Our Reference: Tarrawonga Mod
Your Reference: MP11_0047 Mod 8
Contact Name: Daniel Boyce

Thursday, 27 February 2020

**RE: MODIFICATION 8 TO SSD 11_0047 – TEMPORARY WATER HAULAGE –
TARRAWONGA COAL MINE (MP11_0047-Mod-8)**

Figure 2 | Location of Vickery Coal Mine groundwater bore and infrastructure

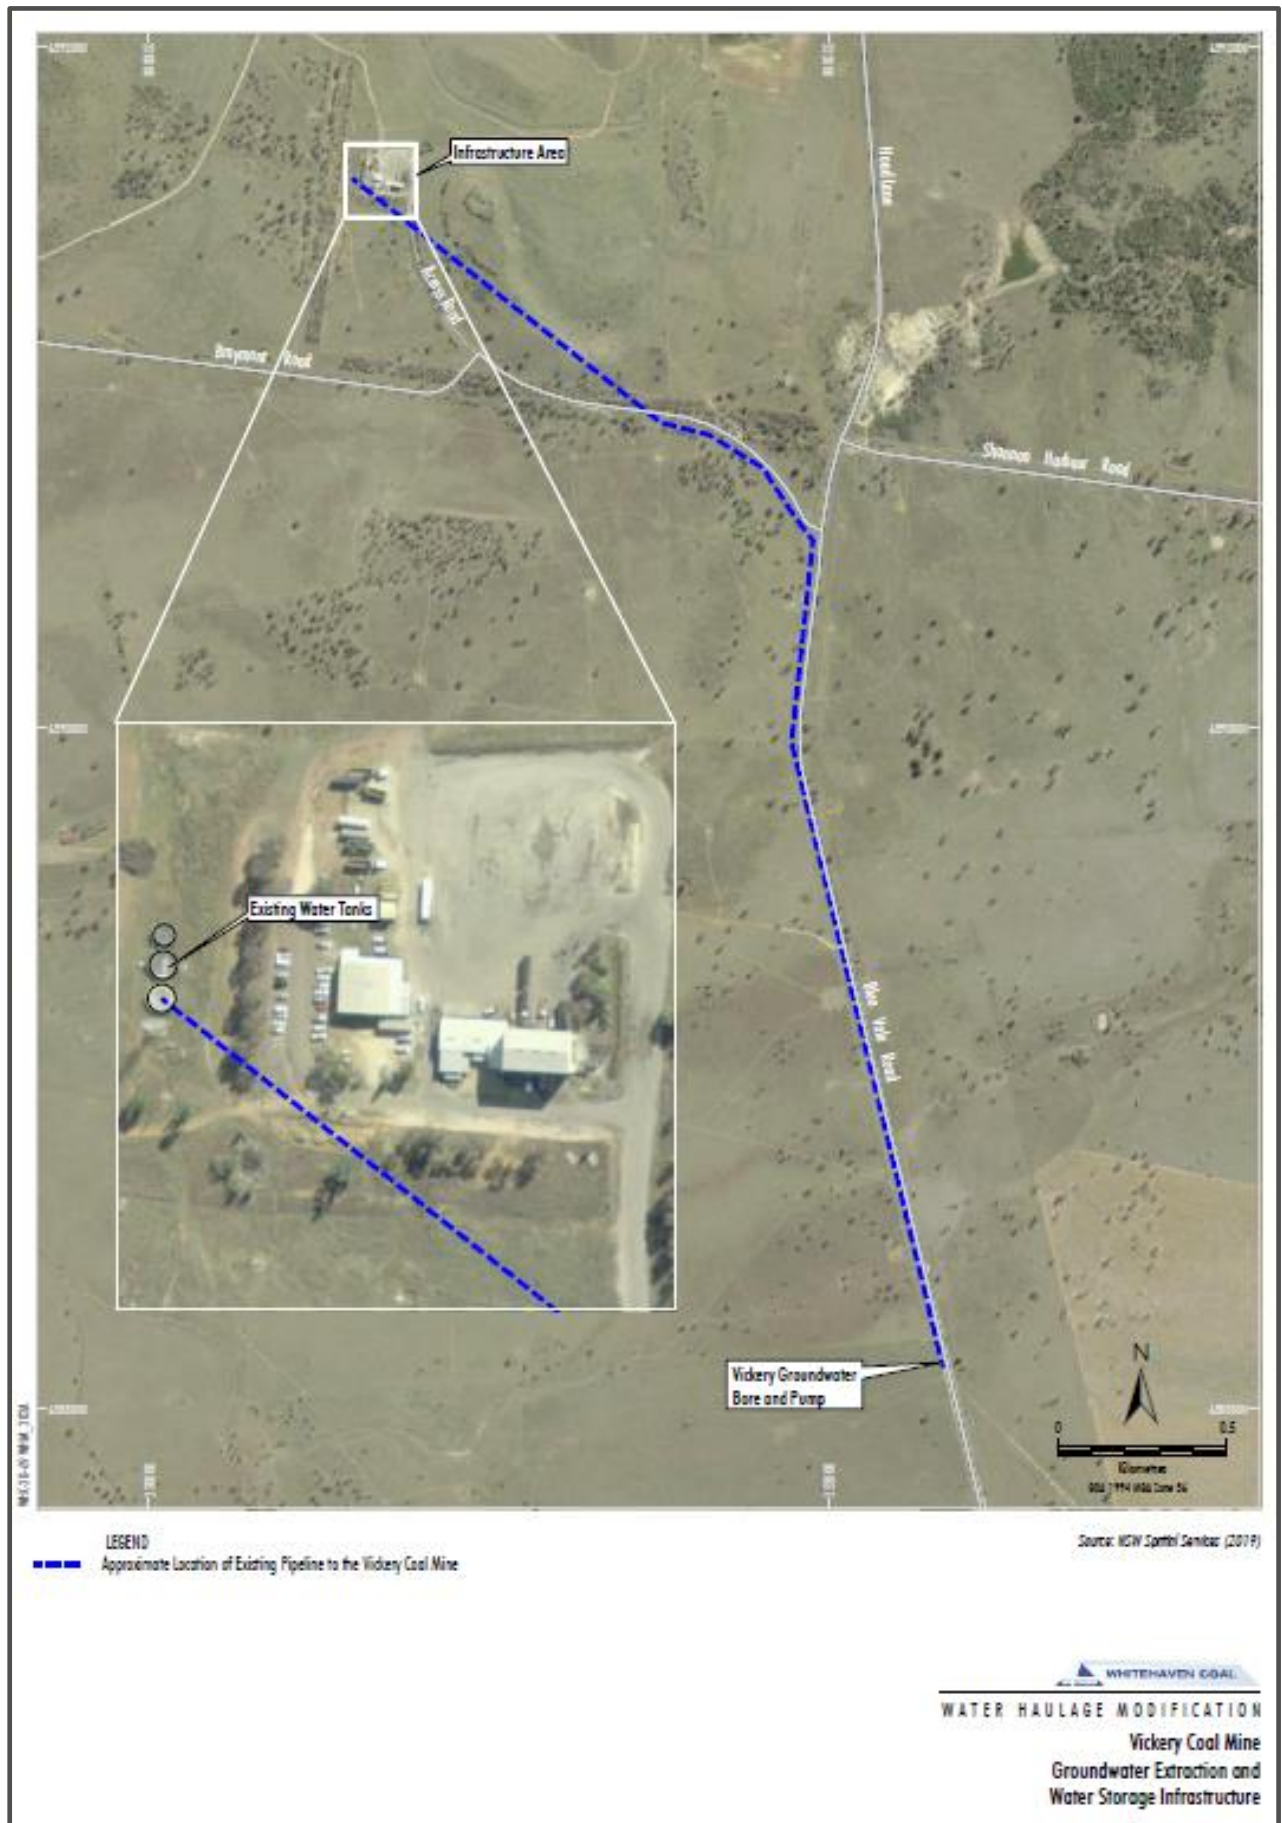
- (a) The application states that the extraction of groundwater and use of the pipelines, tanks and associated infrastructure would be non-exclusive to Tarrawonga. Therefore, further details are required to be provided to

outline how the water supply will be managed between the two sites and approvals.

- (b) The proposed modification intends to extract up to 1.6 megalitres per day of groundwater. It needs to be demonstrated that the bore can sustain the intended yield along with the yields that all other approvals the are relying upon the use of the bore.

- (c) A groundwater impact assessment is to be undertaken to determine the impacts of the modification on groundwater, including any cumulative impacts.
